From: Colin Chandler [REDACTED]
Sent: 26 October 2018 15:55
To: Planning.Responses; [REDACTED]
Cc: Karl Roberts
Subject: 53 Mill Road Avenue, Angmering BN16 4HX

RE: 53 Mill Road Avenue, Angmering, BN16 4HX
Application numbers: A/128/18CLE & A132/18HH

REAR ELEVATION
East

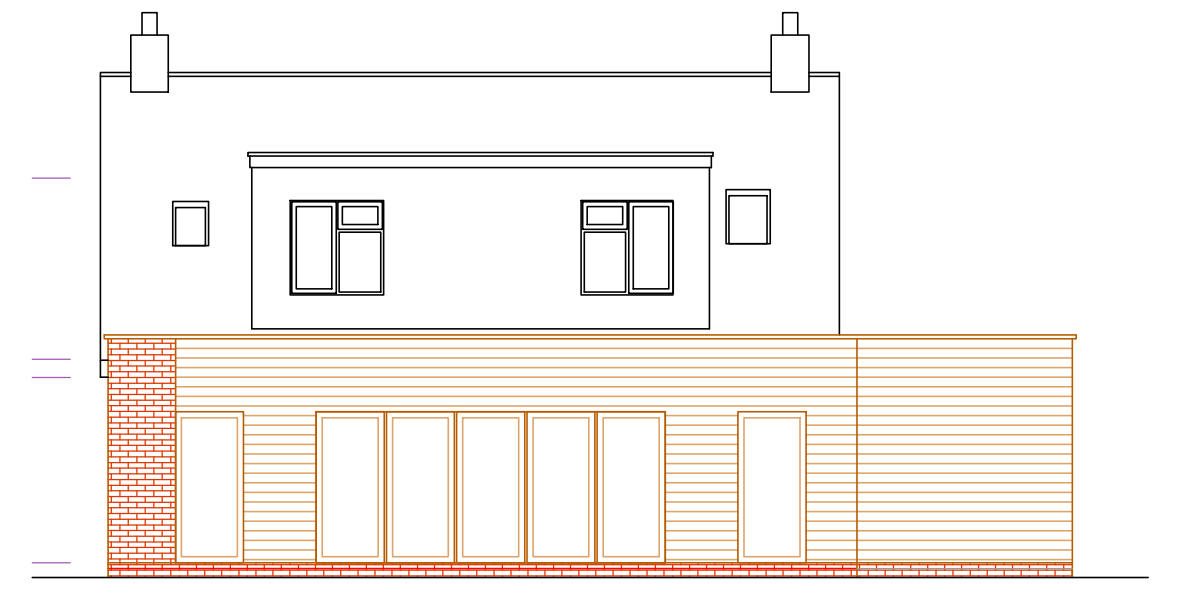
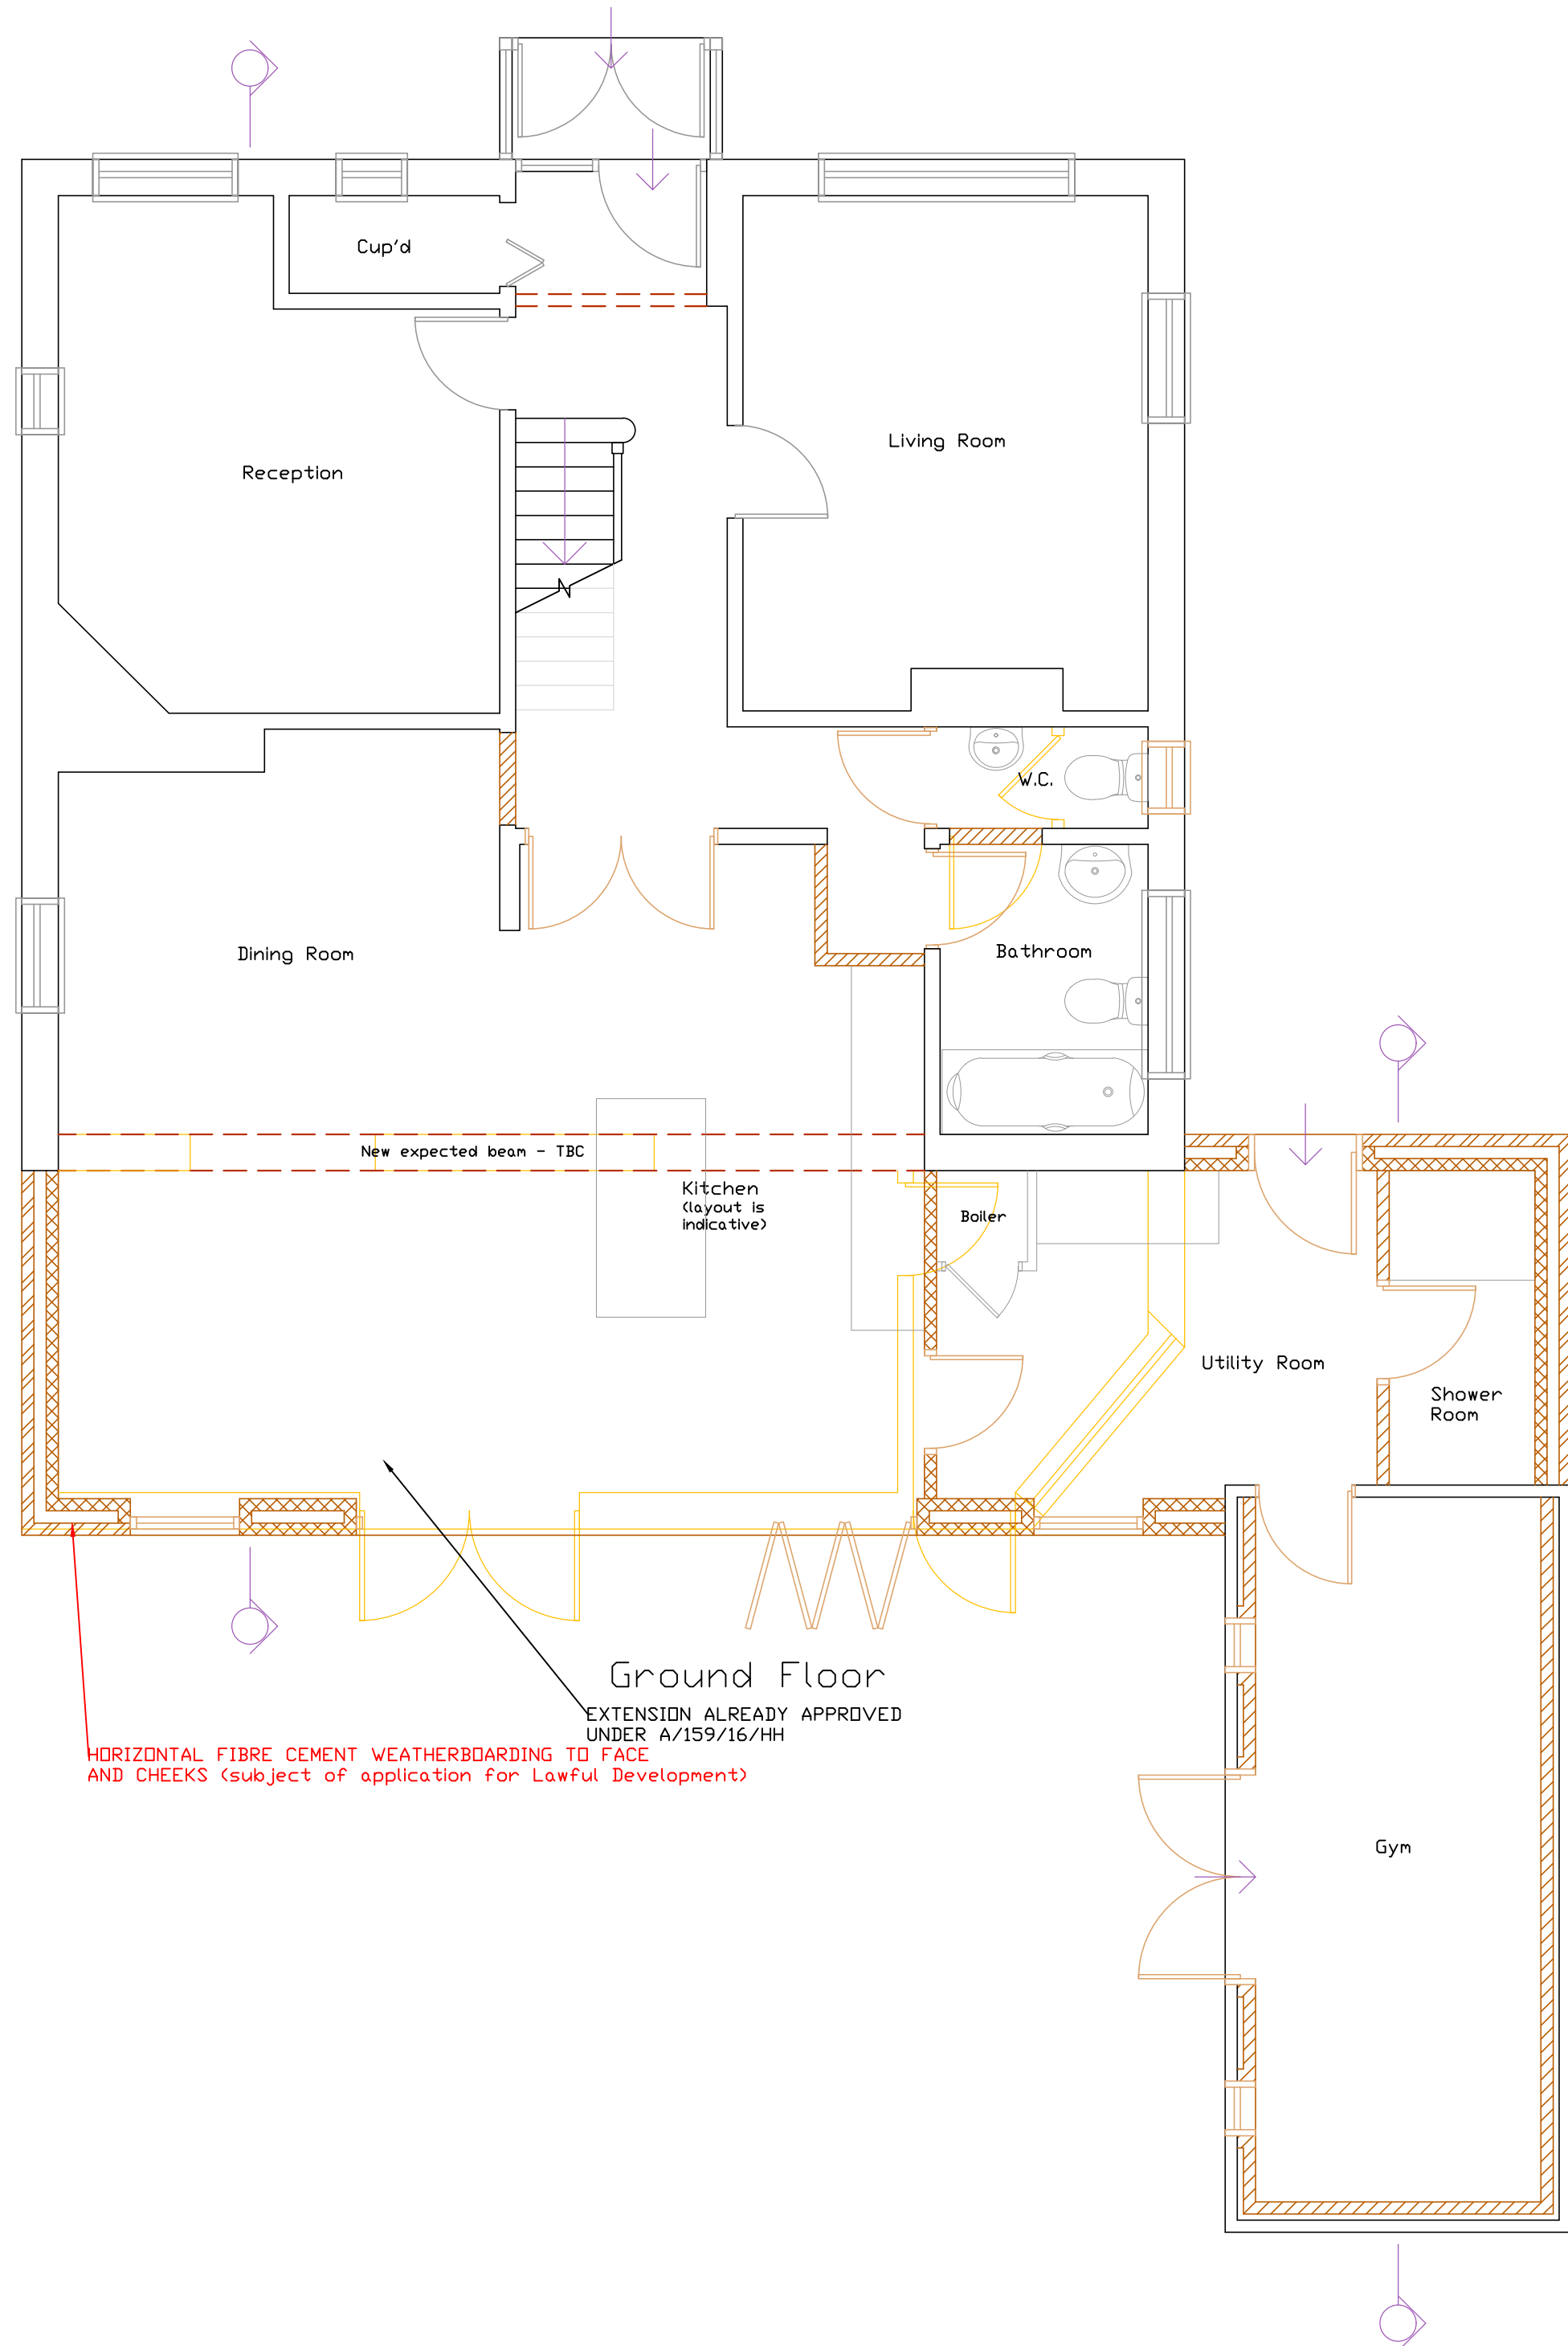
Whereas the "REAR ELEVATION East" on drawing 15060/LDC submitted with application A/128/18CLE shows the dormer as extended with window/door openings, that is not replicated on drawing 15060/02R3 submitted with application A/132/18/HH that simply shows the dormer as previously existing and the approved single storey addition. We are not clear whether the openings we saw formed in the extended dormer before the protective sheeting was added reflect that shown on drawing 15060/LDC and are indeed the final choice, but in any event their design and with the added French doors (presumably as a Juliet style balcony) also seriously begs the question as to whether the advice contained in the second bullet point of the Government's Technical Guidance supporting Class B.2(a) of the GPDO as to whether the interpretation has been fully respected:

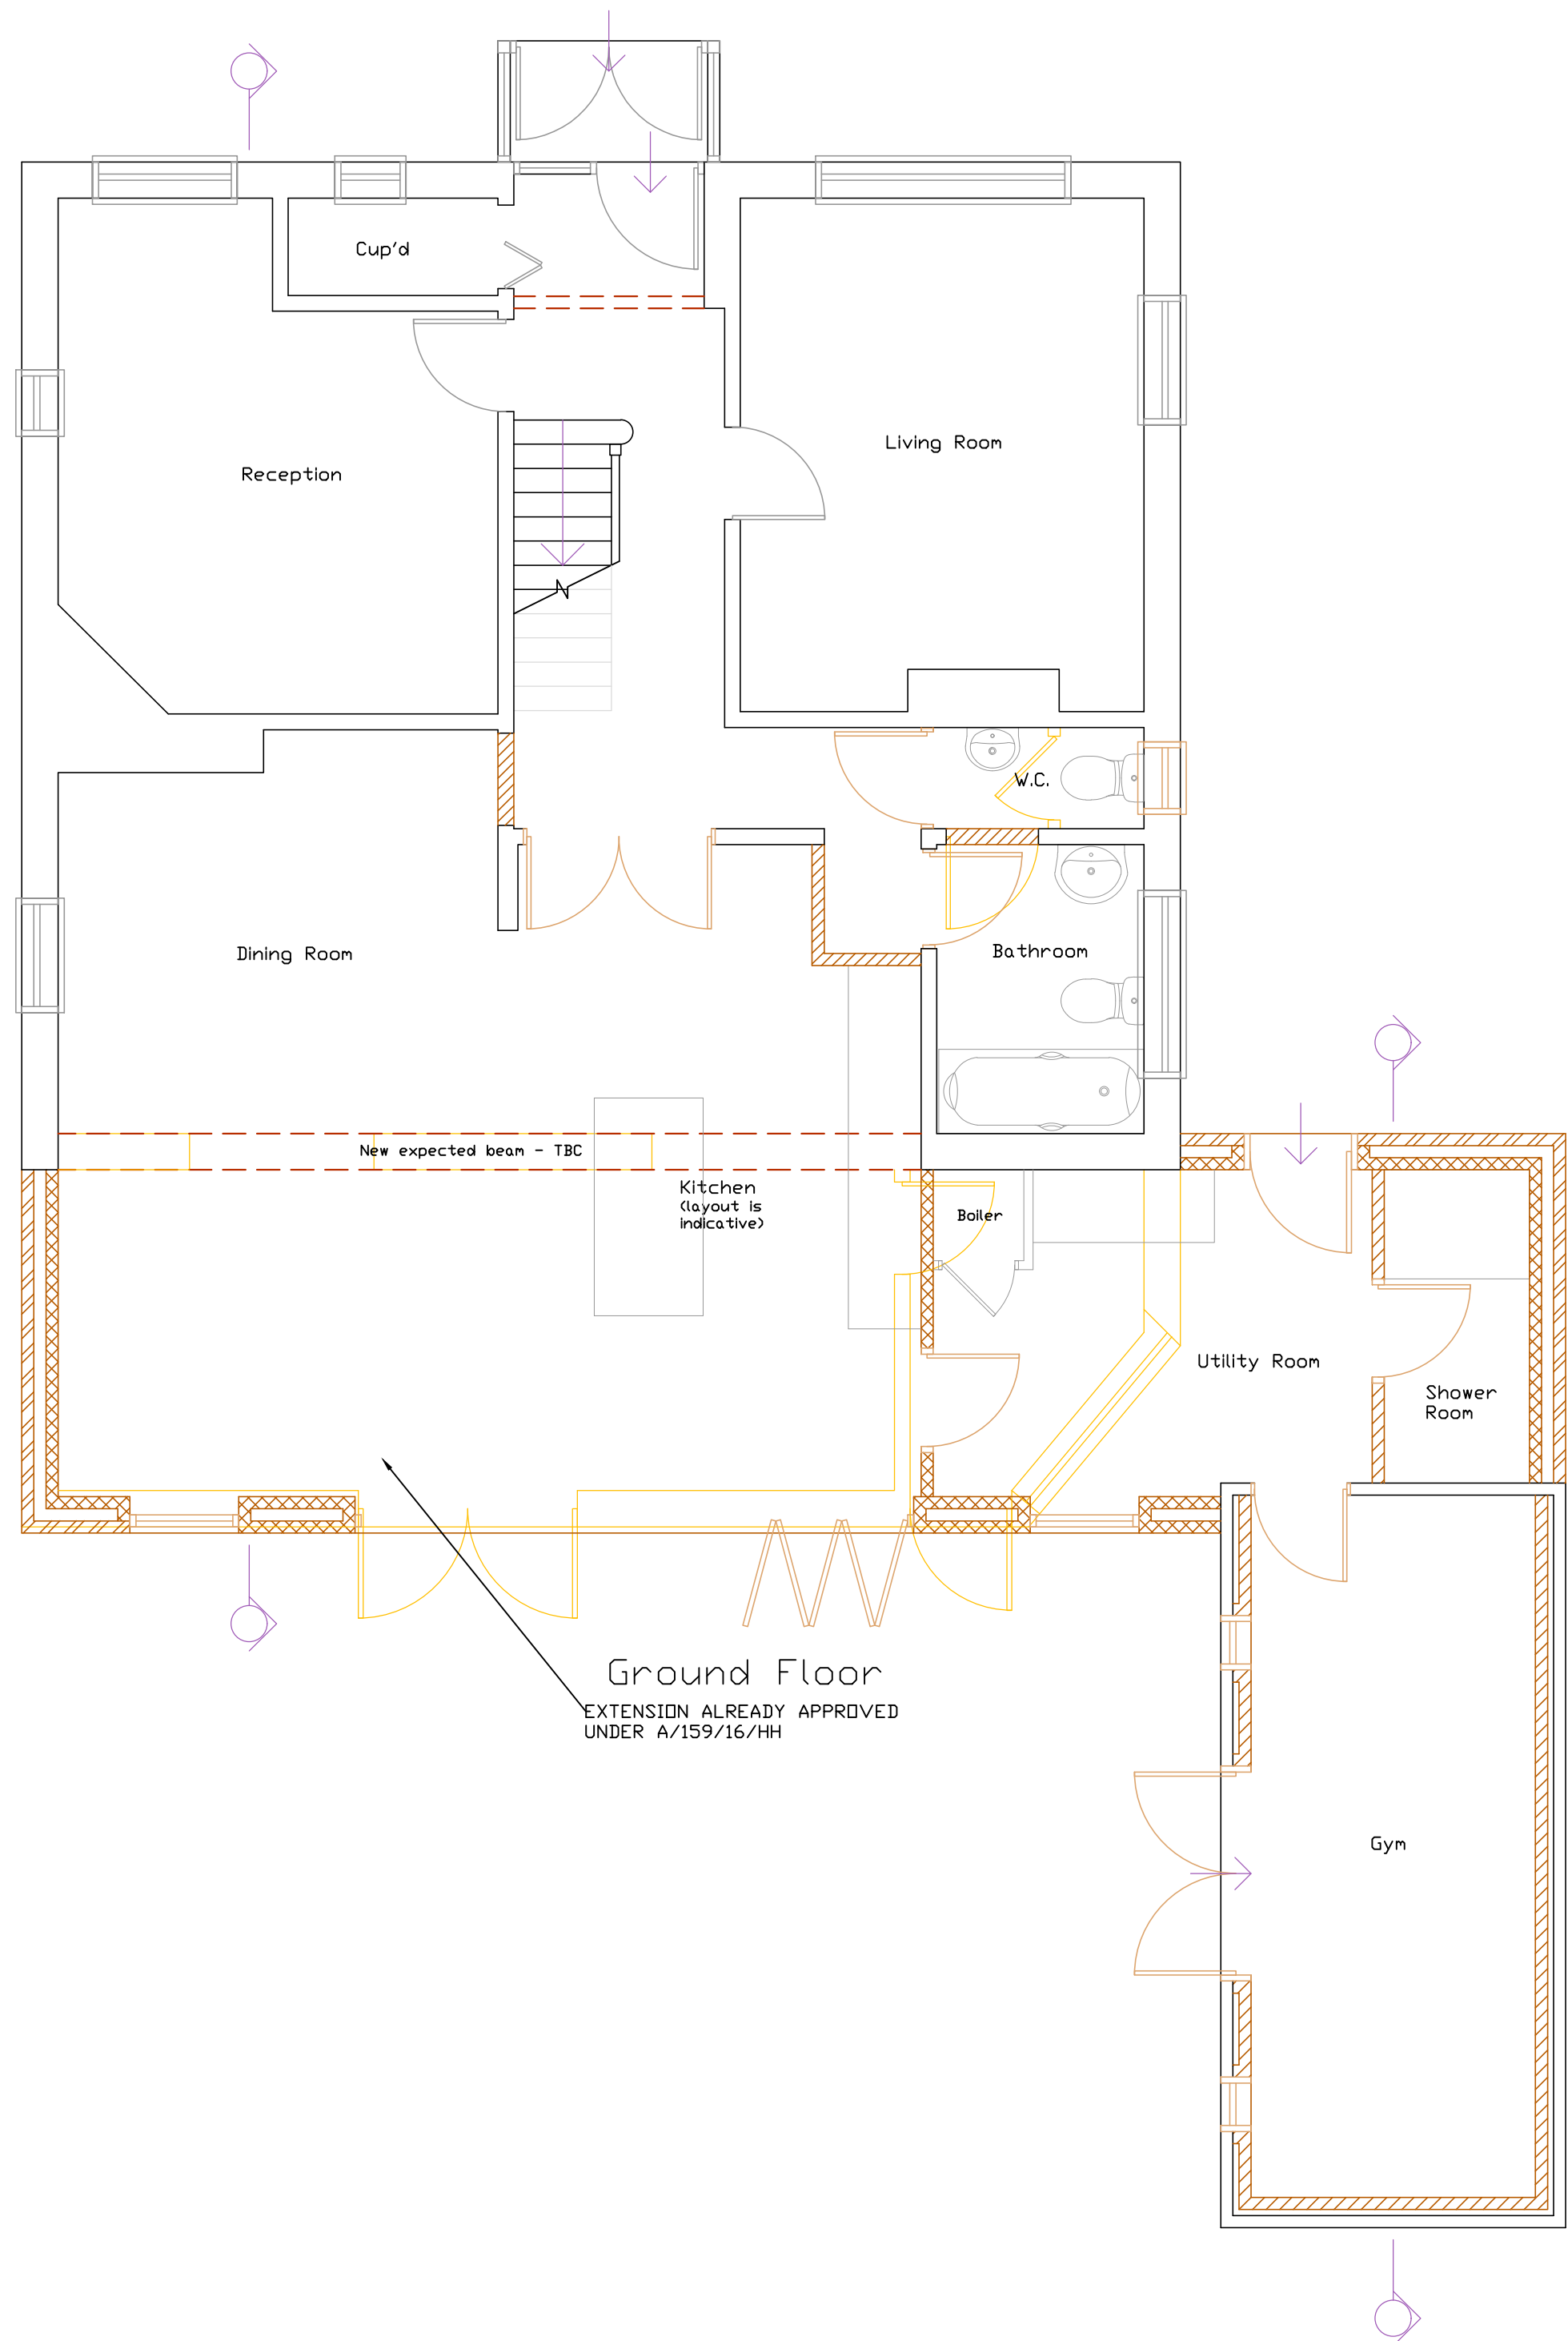
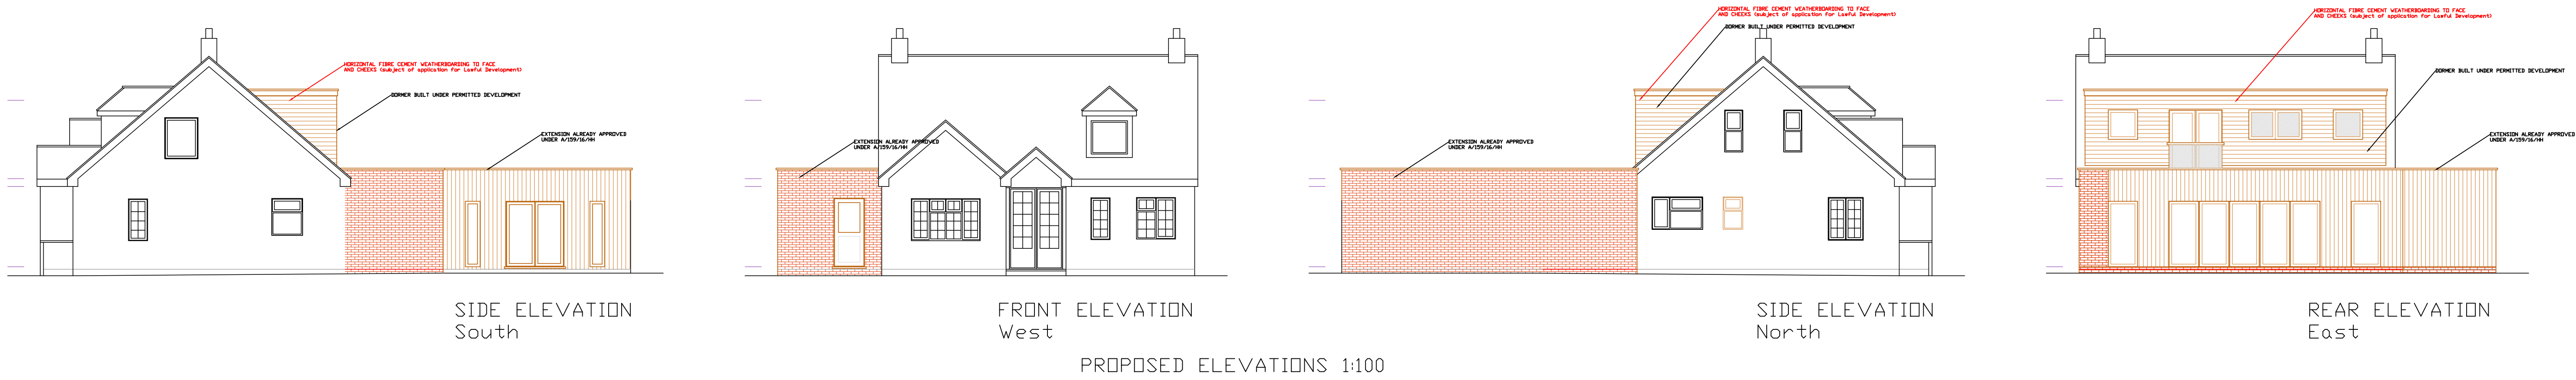
Application A/128/18CLE seeking to verify that a wholesale change in the external material from individual plain tiles to 3.6 metre horizontal lengths of fibre cement weather boarding finished in Light Oak is a 'similar material' as required by Class B.2(a) of the GPDO and to avoid the need for planning permission, is incomprehensible. Having obtained a sample of the weather boarding it is quite clear that adding that material at roof level would be wholly discordant with the remaining plain tiles on the roof slope aside from its visual impact by its mass in the garden scene. The supporting statement by the owner: "Cladding to Dormer", contains factual inaccuracies - i.e. the existing dormer has not been demolished; the "existing planning consent (A/159/16/HH) did not include changes to the dormer and indeed that 2 year old planning permission has not been implemented. So the suggestion that the cladding would blend with existing materials is to date only a proposition and ignores the clash with the current remaining roof tiles. Reference is made to tile colour differences on a neighbouring property, but the fundamental difference there is that the roof slope and dormer are consistent in their use of plain tiles. It is that scenario that where the use of 'similar materials' specified in Class 2.B(a) is understandable given the dormers added to local dwellings are all post original build and inevitably results in colour and weathering differences, aside from availability issues after many decades. To help the interpretation please see the outcomes in the following appeal decisions as examples that highlight that using a wholly different material does not accord with the use of "similar materials" requirement:
